Final Plat OWL RIDGE SUBDIVISION

PART OF THE NORTH ONE HALF OF LOT 2 OF THE SOUTHWEST QUARTER OF SECTION 7,
TOWNSHIP 11 SOUTH, RANGE 65 WEST OF THE SIXTH PRINCIPAL MERIDIAN
COUNTY OF EL PASO, STATE OF COLORADO

Please make comments based on the Final Plat checklist provided. Make sure all applicable items are updated onto the final plat.

Final Plat

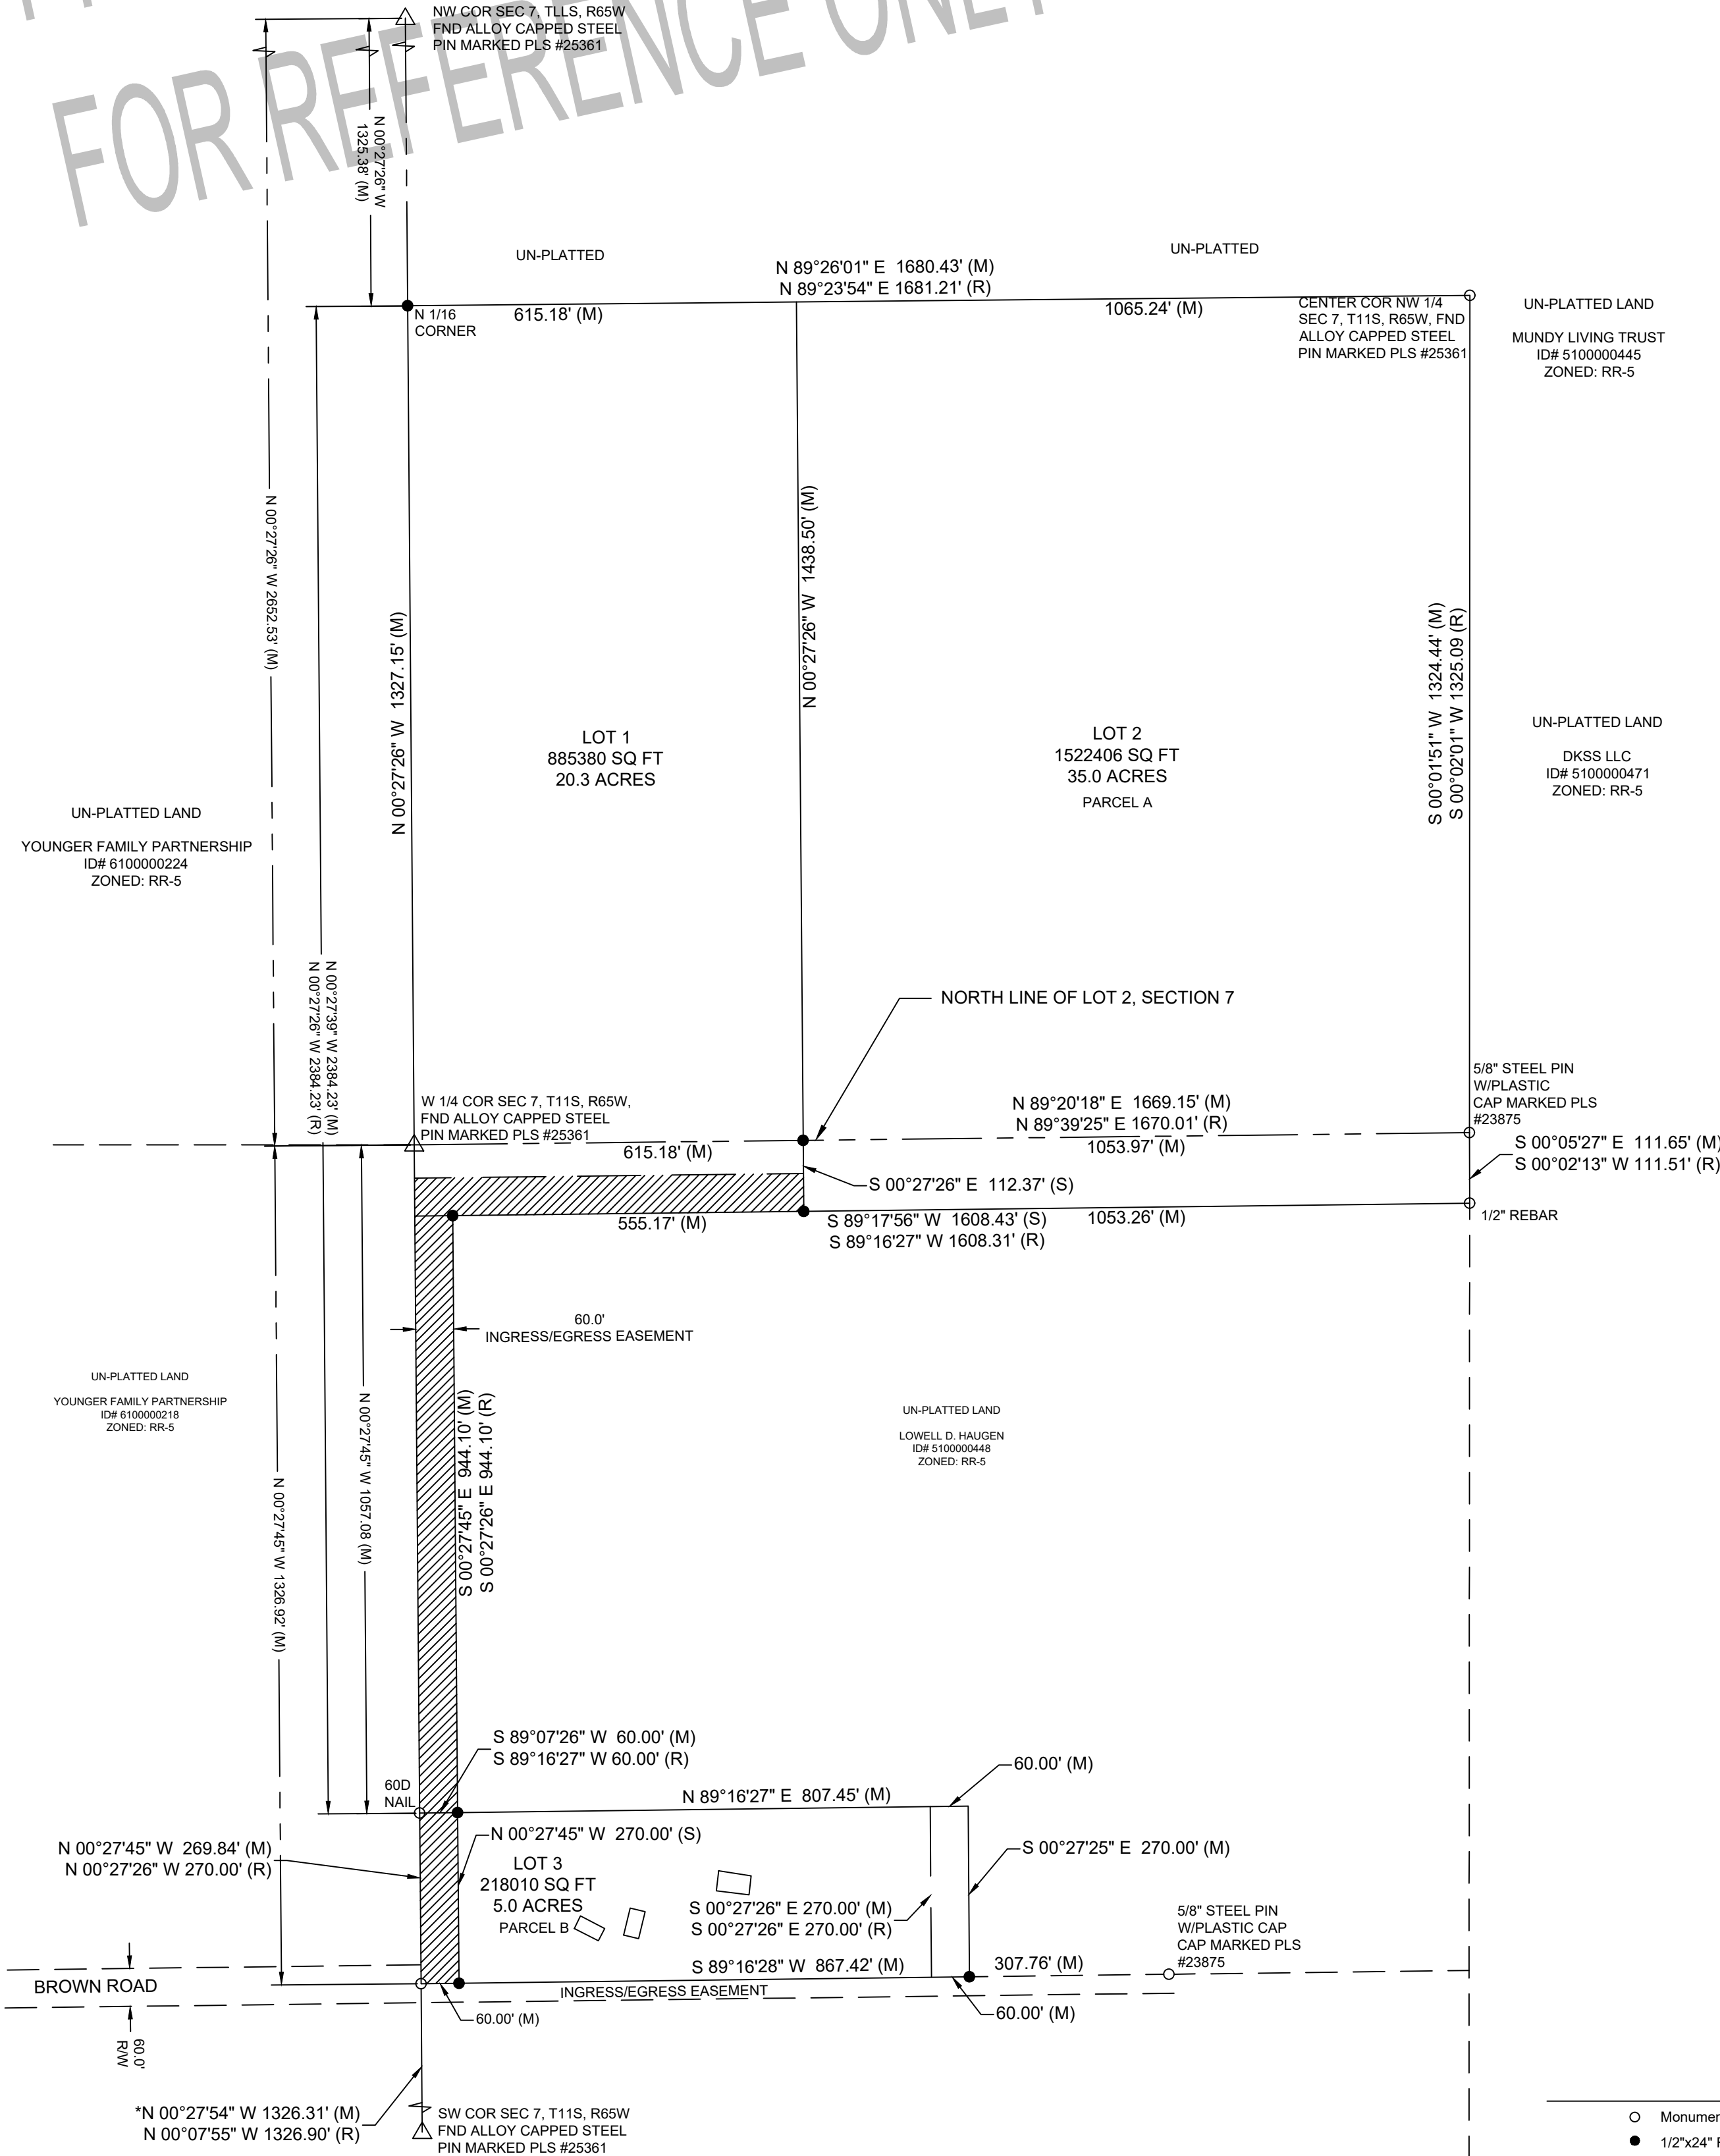
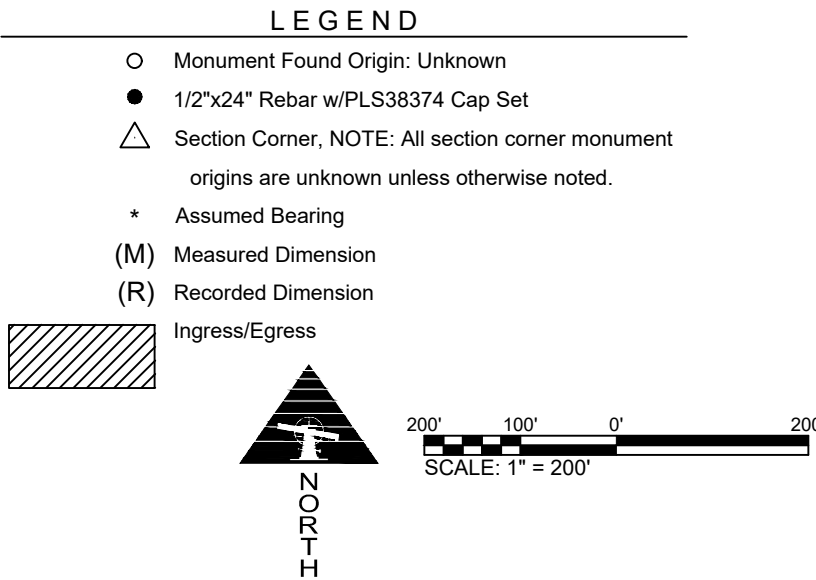
Add note: Individual lots purchasers are responsible for constructing driveways including necessary drainage in accordance with Land Development Code Section 6.3.3.C.2 and 6.3.3.C. Due to their length driveways for lots 1 and 2 will need to be approved by the Fire District Authority

Add Plat Note: The foundation systems for the proposed single-family residential structures and any retention/detention facilities should be designed and constructed based upon recommendations developed in a site-specific subsurface soil investigation

Add plat note for recorded water rights by REC# and , and restricting the further conveyance, sale, transfer, or change in use of the committed water rights.

Please updated Note #11 text to following:
All property owners are responsible for maintaining proper storm water drainage in and through their property. Public drainage easements as specifically noted on the plat shall be maintained by the individual lot owners unless otherwise indicated. Homebuilders are responsible to ensure proper drainage around structures, including elevations of foundations and window wells in relation to side-lot drainage easements and swales. Homeowners shall not change the grade of the lot or drainage swales within said easements, as constructed by the builder, in a manner that would cause adverse drainage impacts to properties. Structures, fences, materials or landscaping that could impede the flow of runoff shall not be placed in drainage easements

Update Note
THE SUBDIVIDER(S) AGREES ON BEHALF OF HIM/HERSELF AND ANY DEVELOPER OR BUILDER SUCCESSORS AND ASSIGNEES THAT SUBDIVIDER AND/OR SAID SUCCESSORS AND ASSIGNEES SHALL BE REQUIRED TO PAY TRAFFIC IMPACT FEES IN ACCORDANCE WITH EL PASO COUNTY ROAD IMPACT FEE PROGRAM RESOLUTION (RESOLUTION NO. 19-471), OR ANY AMENDMENTS THERETO, AT OR PRIOR TO THE TIME OF BUILDING PERMIT SUBMITTALS. THE FEE OBLIGATION, IF NOT PAID AT FINAL PLAT RECORDING, SHALL BE DOCUMENTED ON ALL SALES DOCUMENTS AND PLAT NOTES TO ENSURE THAT A TITLE SEARCH WOULD FIND THE FEE OBLIGATION BEFORE SALE OF THE PROPERTY.

Add Note: Access: No driveway shall be established unless an access permit has been granted by El Paso County.

Add Traffic memo

Please add PCD File # MS-22-005

Please add line type legend

A shared access / easement agreement will be required.

A 30ft ROW from center line will need to be dedicated for extension of Brown Road

Add reception # for existing easement
30' INGRESS/EGRESS & UTILITY EASMT (REC# 204150804)
